Your Ref: OWPC3394
Our Ref: A/99/14/HH 20-07-2014
Please ask for:
Mr D Sullivan

Removal and reconstruction of part of the front boundary wall (resubmission following A/46/14/HH). This application affects the character and appearance of the Angmering Conservation Area.

2 Woodford Villas High Street Angmering

DRAWING TITLE
PROPOSED FRONT BOUNDARY WALL
ELEVATIONS, PLAN AND SECTION

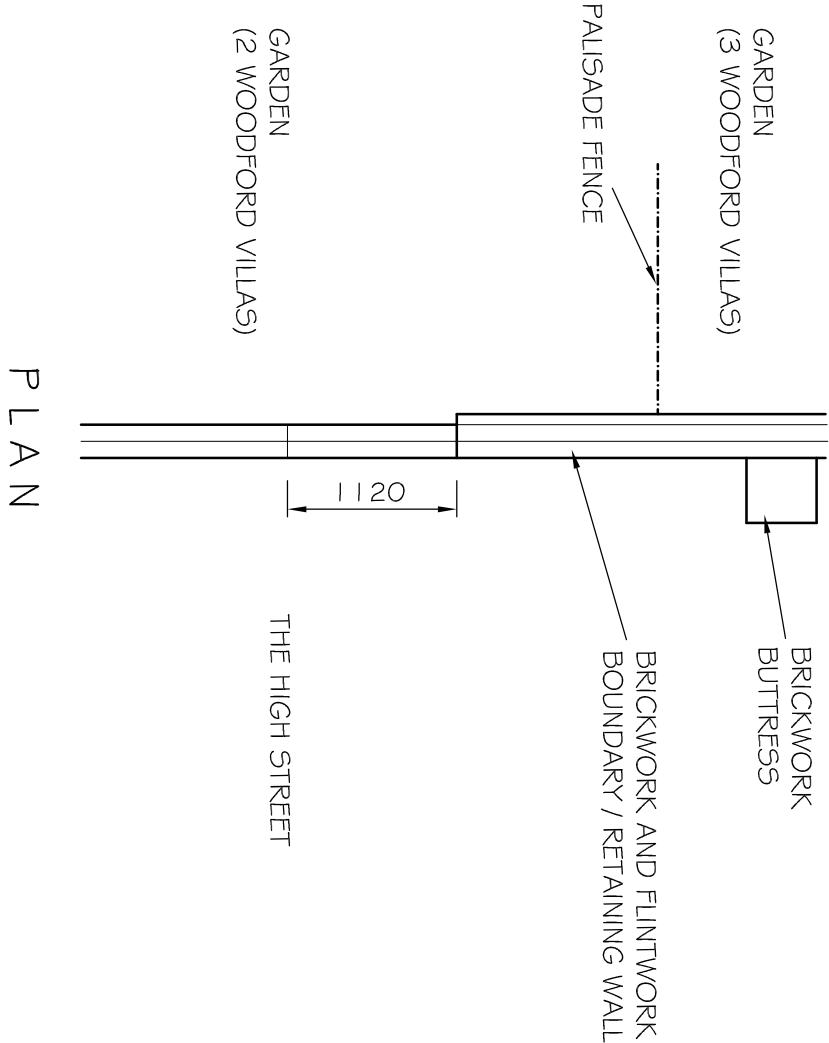
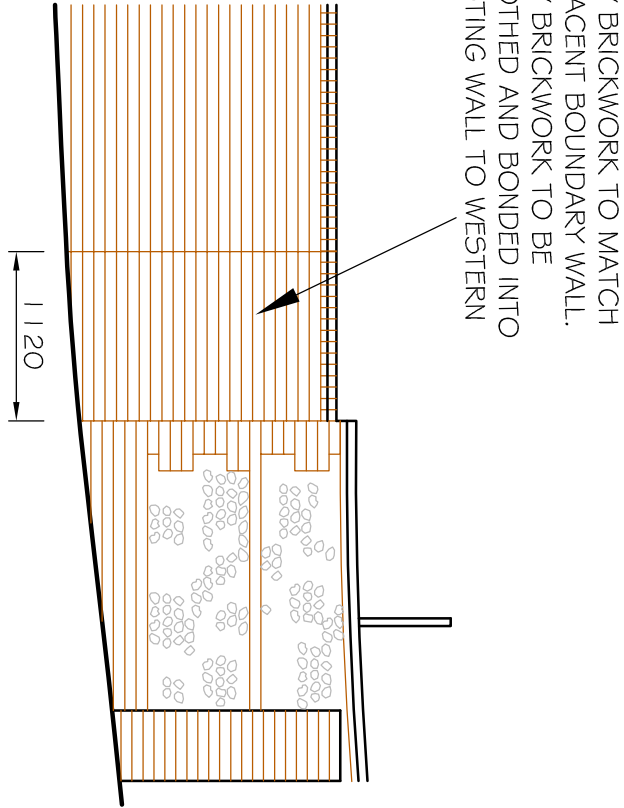
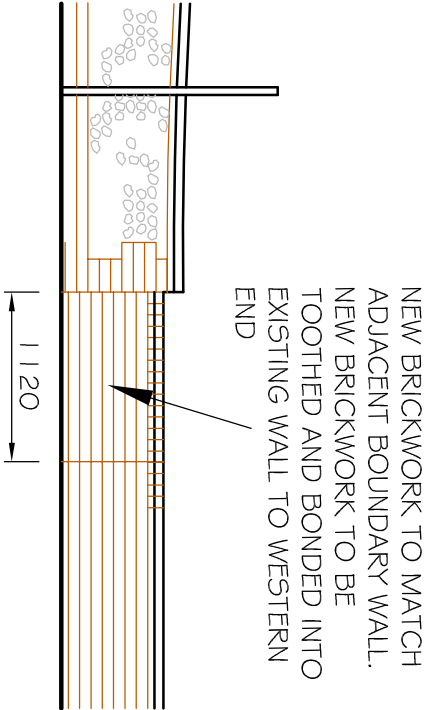
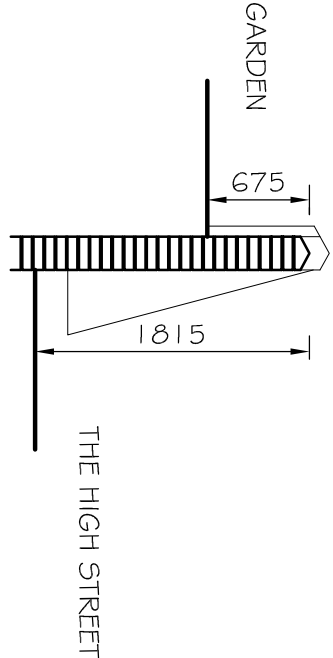
Any wall built here will block a historic access to other properties. The original steps that were in place before the red bricked wall was built were in keeping with a conservation area. A new bricked wall will not be as there is an old flint wall either side.
